**Works to Existing shop at 3 High Street, Clare, Suffolk, CO10 8NY  
(formerly known as Hudgies Hardware)**

**Listed Building Consent ref: DC/21/2024/LB**

**Submission of details in respect of Condition 3**

## **Schedule of Works to repair and refurbish existing shop**

PROPOSED FRONT ELEVATION

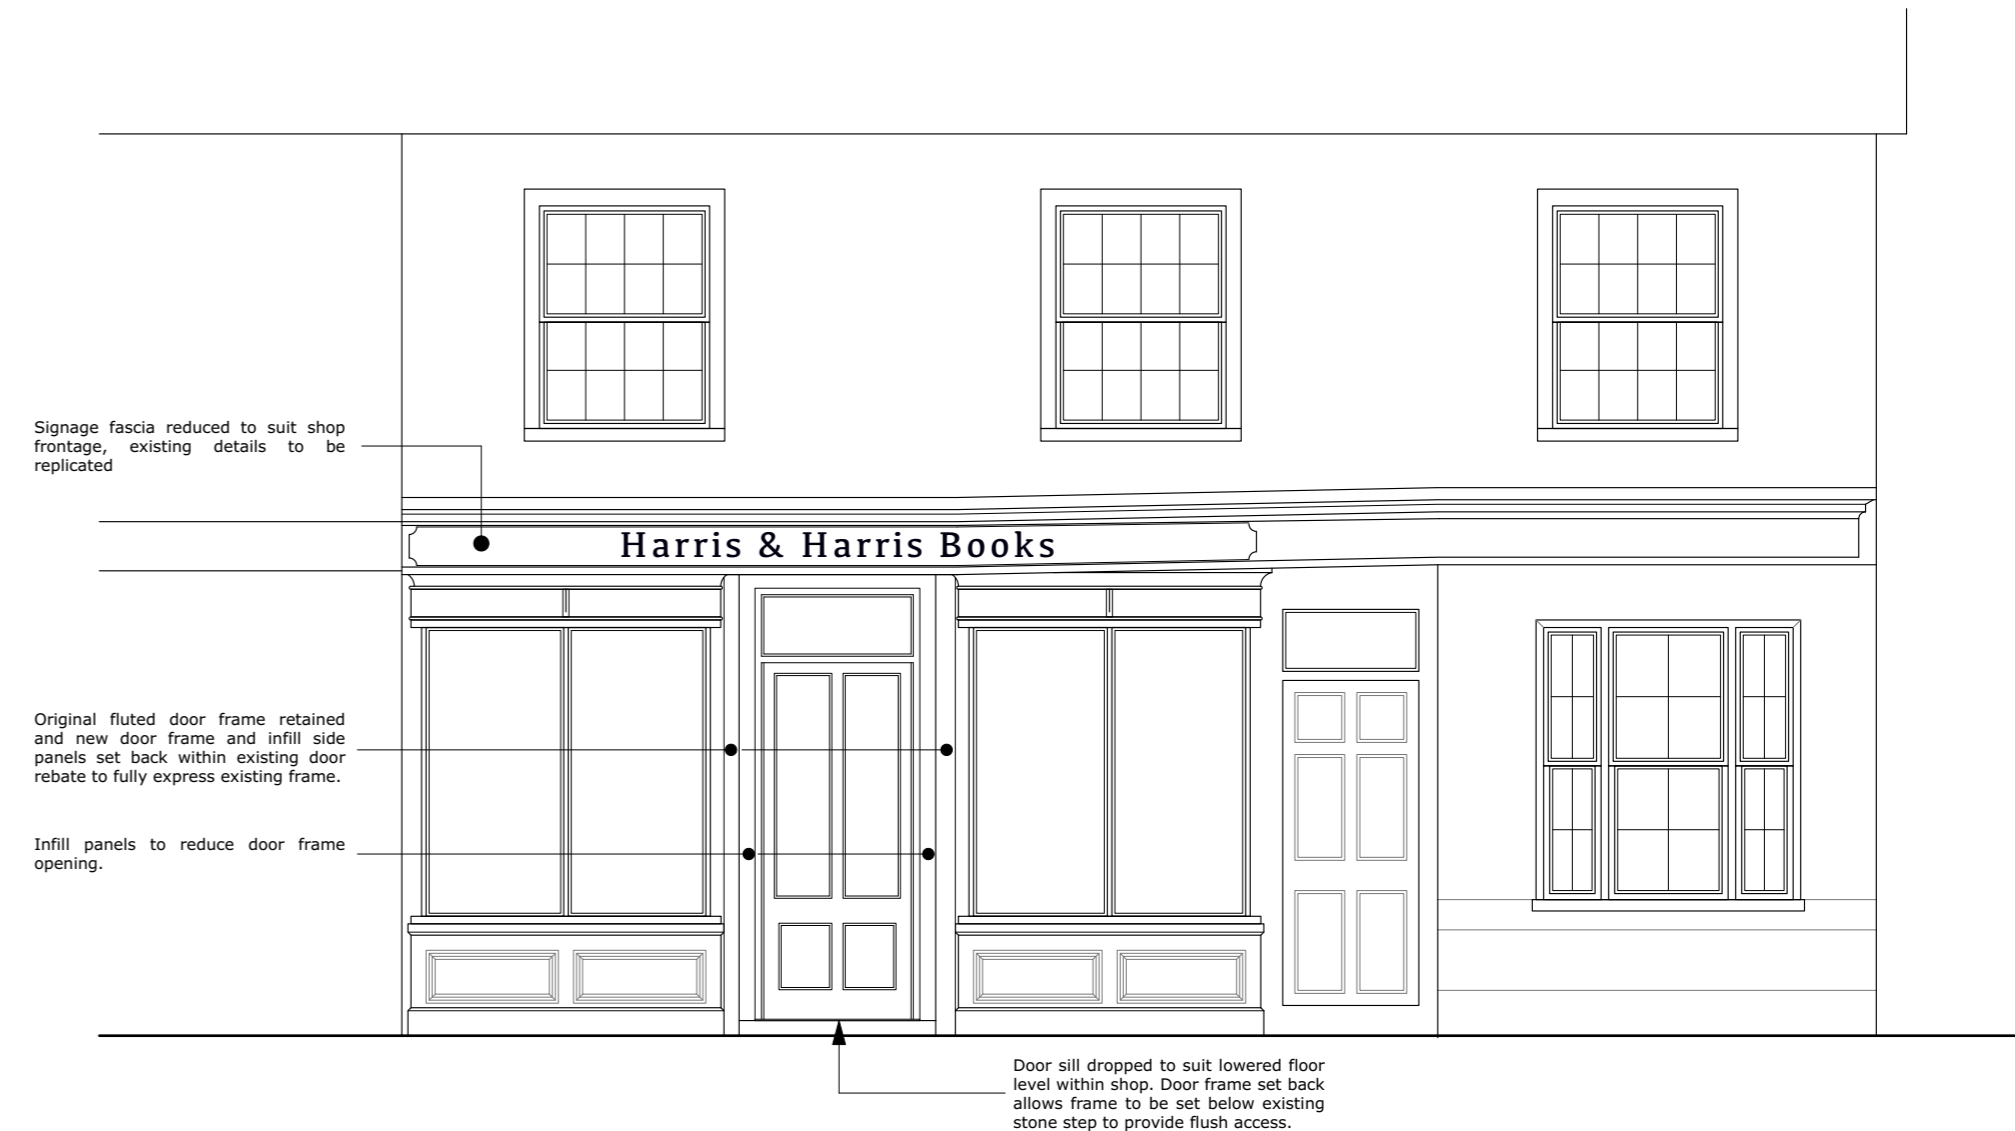
*The replacement front door proposals from the Client's joiner are attached for your consideration. I also attach Existing Survey and Proposed Elevations to show the door in context.*

*The proposal for the shop signage is to retain the existing fascia construction but reduce the signage element to relate to the shop premises to create a clear distinction with the adjacent dwelling house. This will be further enhanced with a change of colour between the two premises.*

*The existing pull down canopy and support brackets are to be removed and replaced with a new canopy. The replacement canopy proposal will be the subject of a separate Listed Building Application when a suitable product has been sourced by the Client.*

*The list description for the property is scant, but does refer to the shopfront as being of the 19<sup>th</sup> century. This is borne out by the evidence uncovered on site. The blind box and canopy, on first sight, appeared to be a historic feature of the shopfront, although not mentioned in the list entry. Having looked at it more closely, however, it appeared to be a later addition as they are usually integrated within the fascia, below the cornice surround. It also struck me as odd that, if was original, why it didn't span the full length of the fascia to match the signage, as the shop and house were in the same ownership and occupation. I therefore looked into it further and found the image below, dated as early 20<sup>th</sup> century (the image is a snip from the original found the website linked below it). This clearly shows the absence of the blind box confirming it to be a later addition. Its modification or replacement could therefore be justified on that basis. The new canopy should reflect the traditional style and detailing to ensure it is appropriate to the shopfront and the conservation area.*

*It is probable that the doors are contemporary with the rest of the shopfront but have undergone alteration in the past with the addition of the framed glazing and introduction of various handles and locks. I would also expect the bottom rail to be equal in depth to, or deeper than, the midrail, so this also looks to have been altered in the past, possibly with the raising of the internal floor level. I appreciate the difficulty of access for wheelchairs, pushchairs etc with the individual leaves being too small but when combined being too large and heavy. The replacement of the existing doors with a single door of a more standard width, but which incorporates the traditional detailing such as the gunstock stiles, could be justified on the basis of improving access for all with little harm to the significance of the building due to the alterations to the doors which have already compromised their integrity.*

Project	Works to existing Shop and Dwelling at 3 High Street, Clare for Mr & Mrs Harris		
Title	WORKING DRAWING : GROUND FLOOR PLAN & REAR LEAN-TO SECTION		
Scale	1 : 25, 50 @ A1 page size	Date	Sept 2022
Drawing No.	21029-05	Revision	A

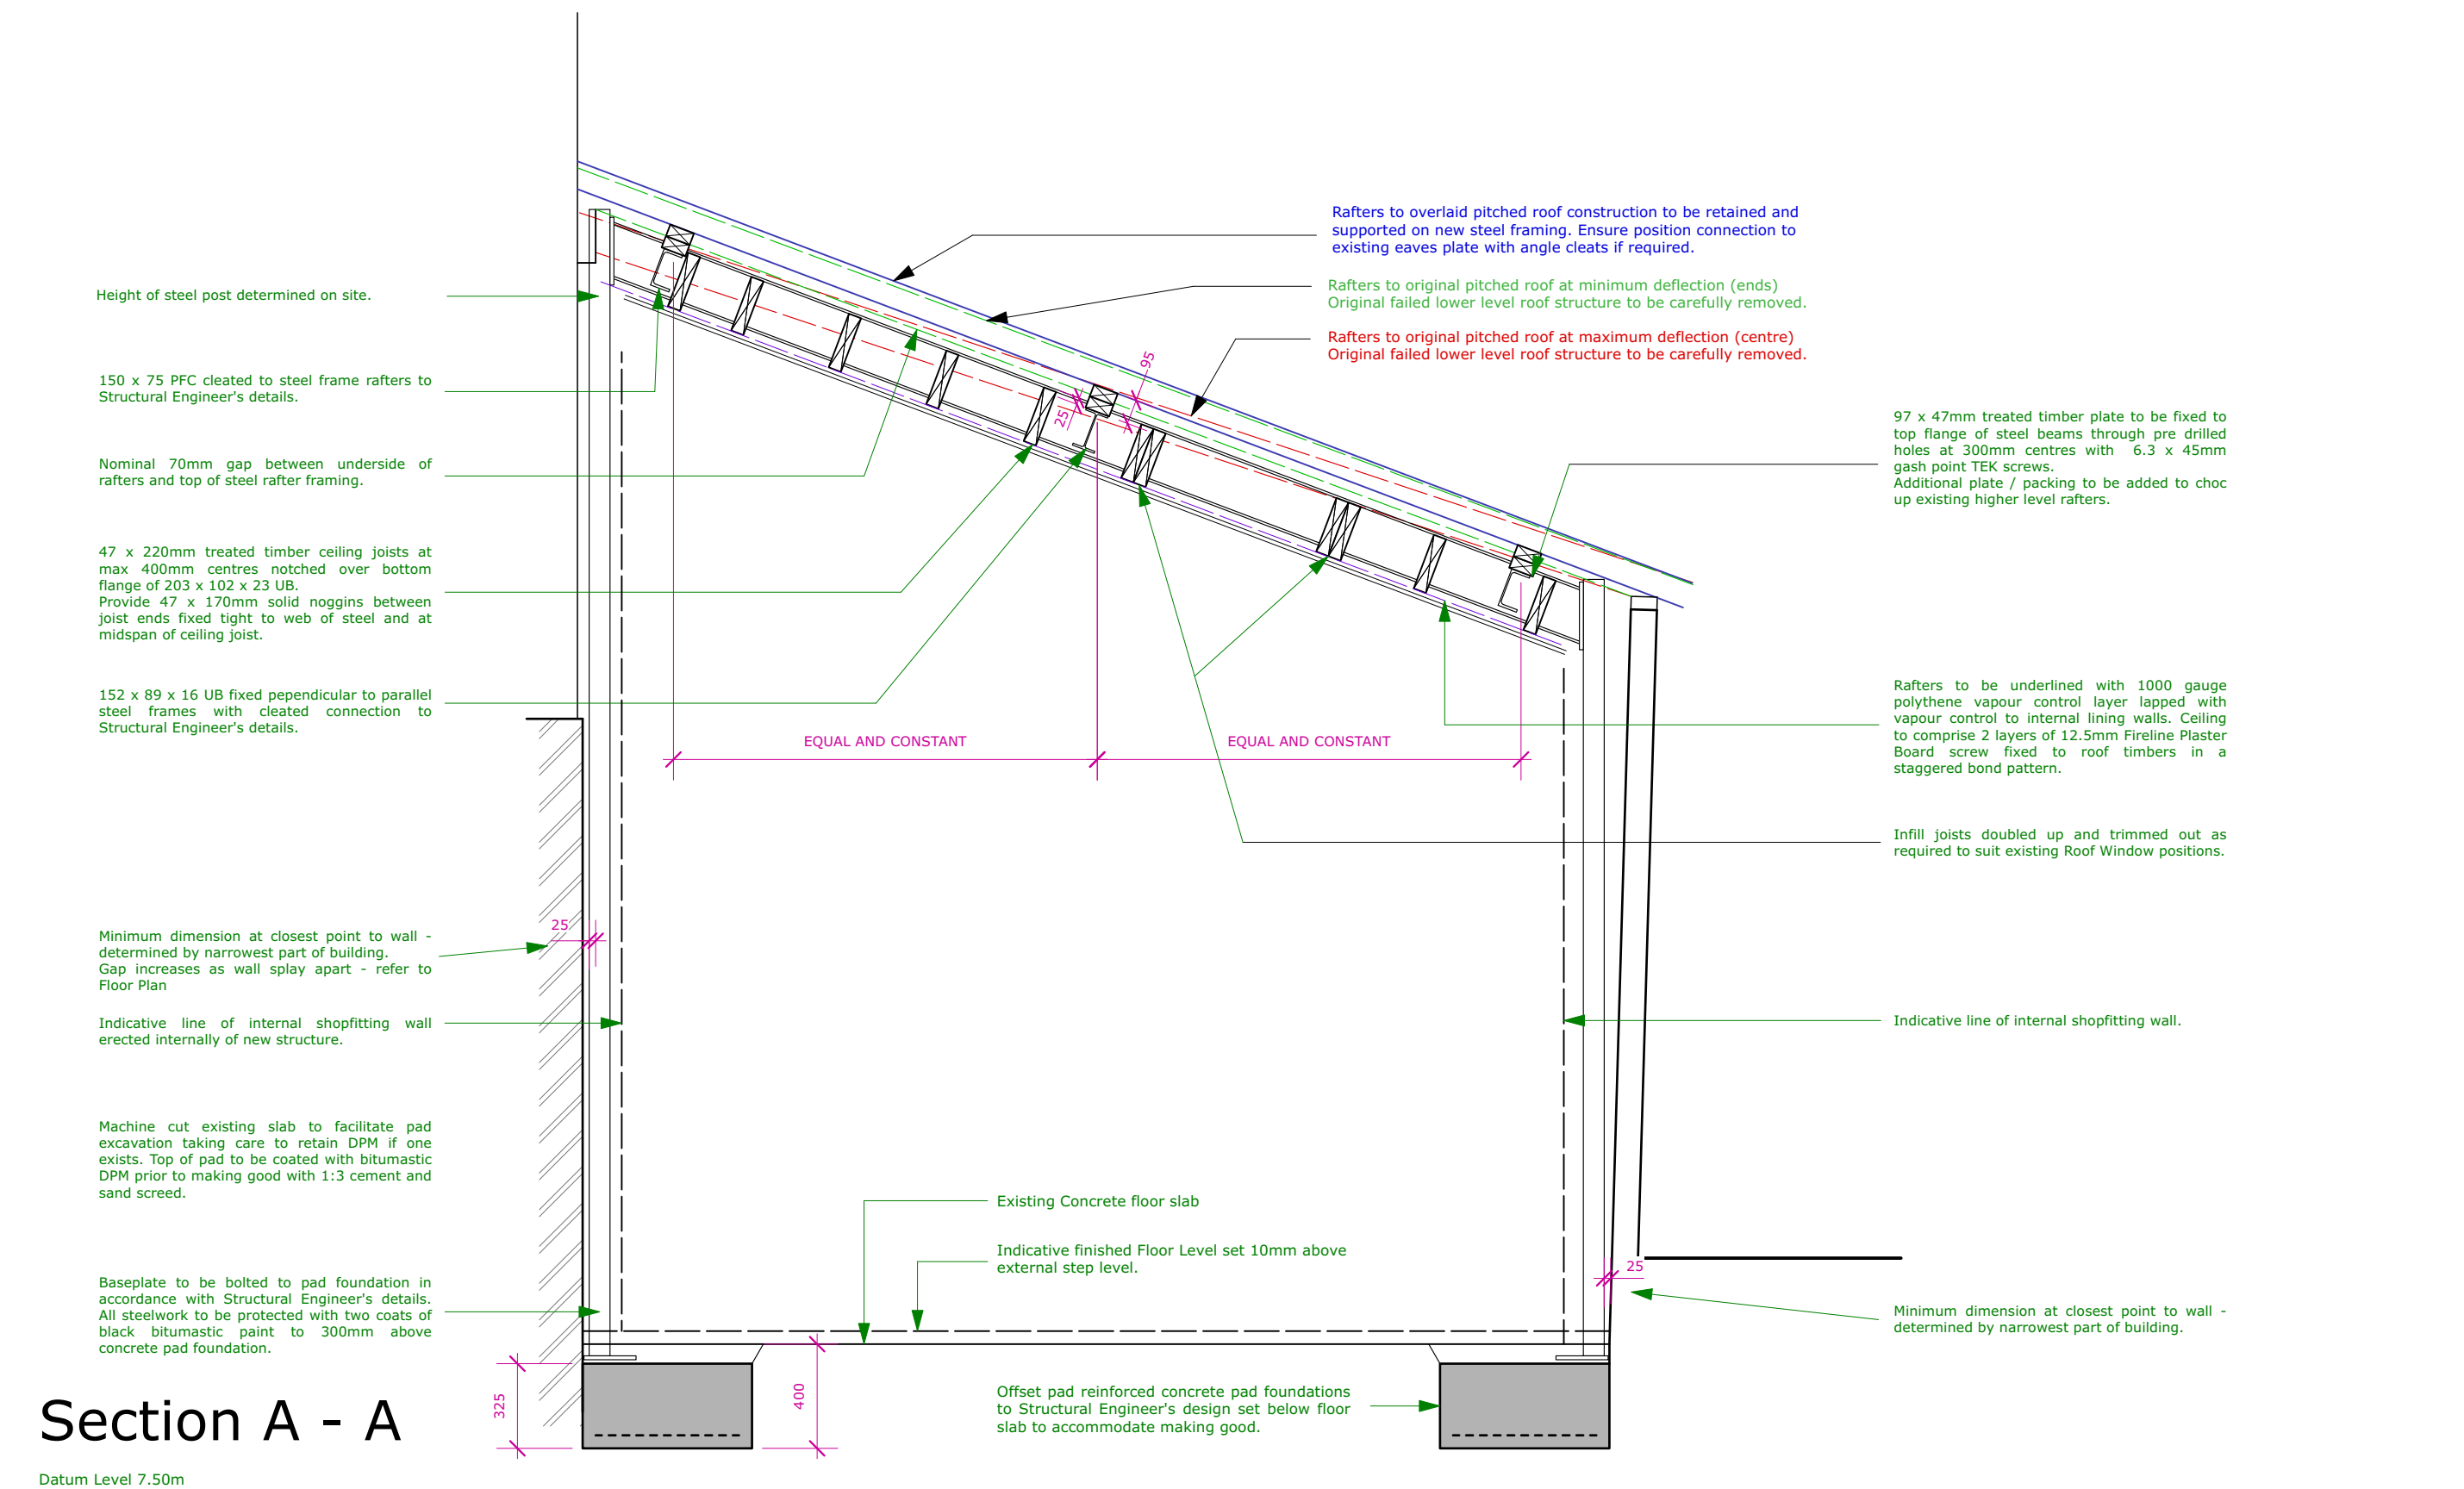
Refer to Working Drawing 21029-05B for details of:

1. New partitions to create rear lobby.
2. New footing to collapsing internal wall
3. New acoustic and firelining to existing wall between shop and existing dwelling
4. New steel frame and foundation to support existing rear lean-to roof.

- a) Replacement of decayed and non-continuous soleplates to rear section of building (shaded pink on plan) with treated timber softwood sections to match existing construction.

- b) Replacement of Post F with new oak post. The original post was no longer in existence with a partial section clamped and bolted between two wide softwood plates. The support to the main beam above was tenuous contributing to the severe deflection in the floor structure.

- c) New concrete pad footings and brick supports to front elevation posts A & D. While the posts had structural integrity the supports had rolled/decayed, reducing the support to the first floor structure and external wall.

- d) A new step created on the line of the previous sloped section of floor in the rear lobby. This location corresponds with the vaulted brick arch to the cellar below. The step was formed using a fire board fire stop and the remaining partial section of Post F used as a threshold step to preserve the original material within the building.
